AL/56/22/PL

Boundary wall to Nyton House Nyton Road Westergate PO20 3UL

Part demolition of boundary wall to form new access to existing site (resubmission following AL/10/22/PL). This application affects the setting of a listed building and is in CIL Zone 3 (Zero Rated) as other development.

Photographs of the existing wall

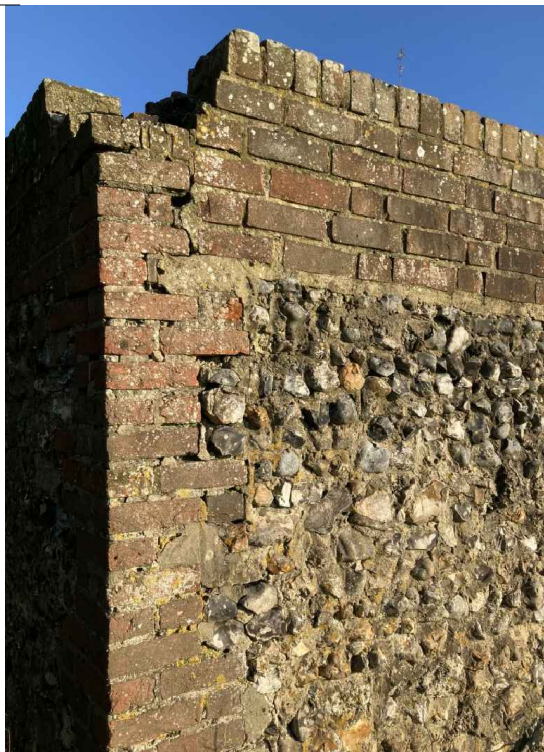
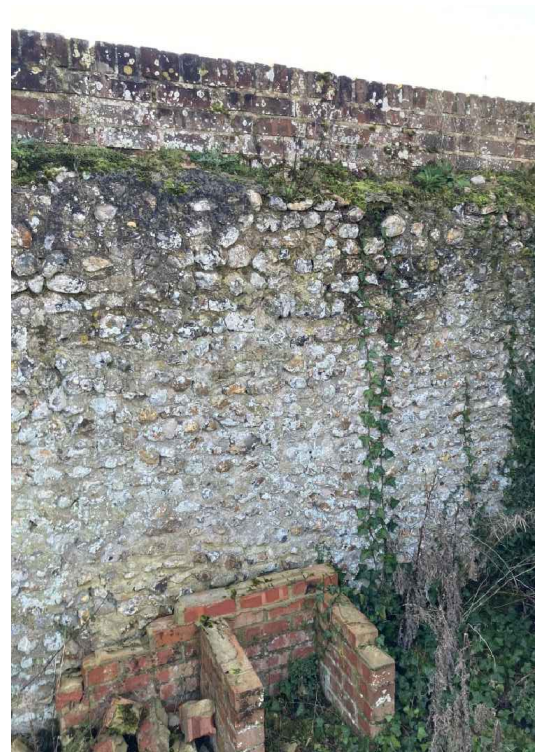
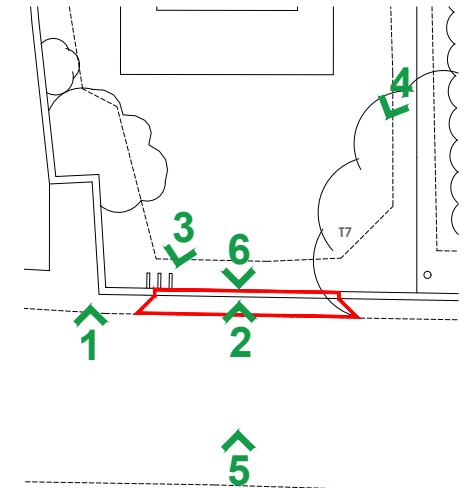
containing numerous examples of cracking, dilapidation and historic damage. It is also noted that there are 6 rows of bricks to the top of the wall which somewhat increase its height.

I would want to make sure that the quality of the rebuild is high and reflects the existing. A sample panel would be required, along with details of the proposed mortar mix – this could be based on an analysis of an existing sample.

Site Plan
showing proposed works

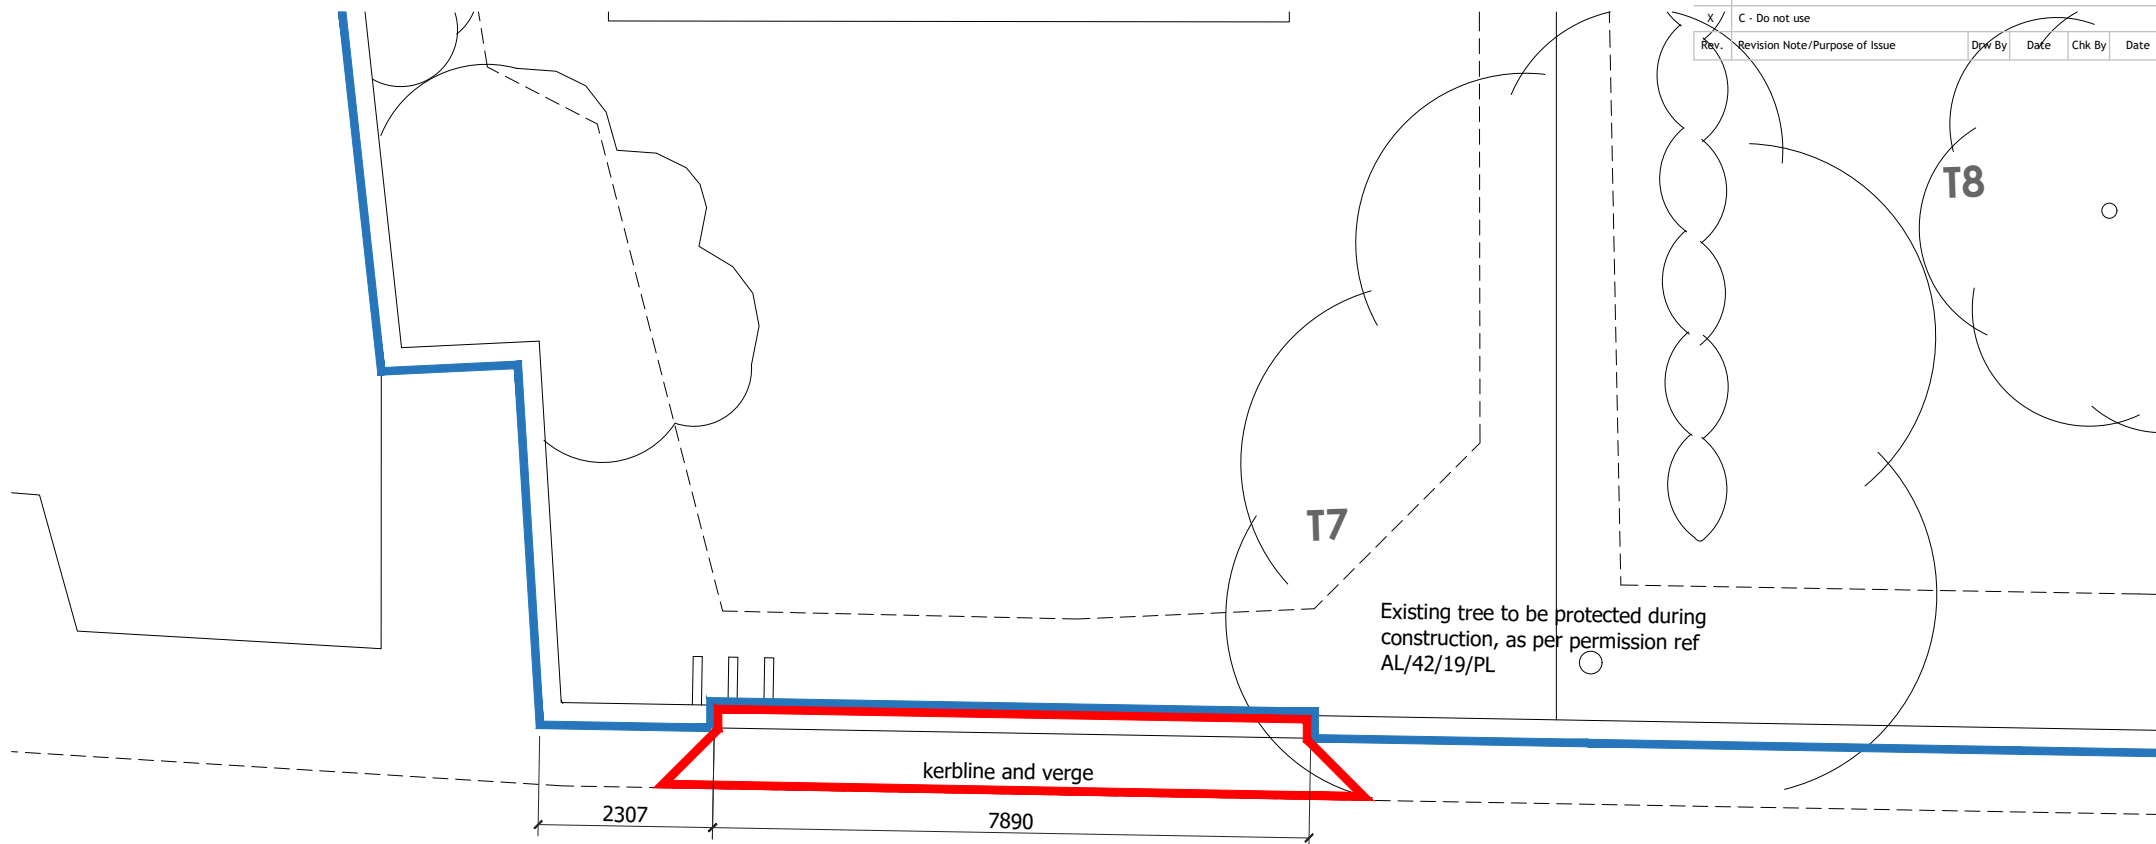
The application relates to the part demolition of the boundary wall in order to form a new access. This implies that the section of wall is to be removed on a permanent basis. However, a review of the Design and Access Statement shows that the “wall forming the basis of this application is proposed to be removed temporarily and reconstructed on completion of the construction works”. This seems to imply that the section of walling will be re-built when the new development within the site has taken place. Please can it be conformed which is correct? If it is the later, would the description of the application need to be amended to clearly reflect this, as at present in approving the application would we only be consenting the removal?

The section of the wall is to the western edge of the site of Nyton house and faces onto Nyton Road – it forms part of the curtilage of the house and is therefore curtilage listed. An area of approx. 8m width would be removed as part of this proposal which the agent identifies as

The sensitive repair of the wall is acceptable, and if this would require that this section is removed and replaced so that it looks like it does now, minus the structural issues, this would seem to be acceptable. I would only want that part of the wall which needs to be removed/repared taken down. It would help to have a more detailed record of the walling so that the reconstruction could be carefully assessed and managed (e.g. details of the flint coursing etc). Also, all of the existing flint and bricks should be carefully cleaned and retained on site so that it can be re-used as part of the rebuilt wall. This historic fabric should not leave the site!

It is also not clear how the exposed sections of the walling will be treated for the duration of the works (i.e. would quoins be constructed?), what the gates identified on the proposed site plan will look like, how long it is anticipated that the section of walling would be missing, or how long after the opening is required as a means of access that the wall will be re-built. This information should also be provided.
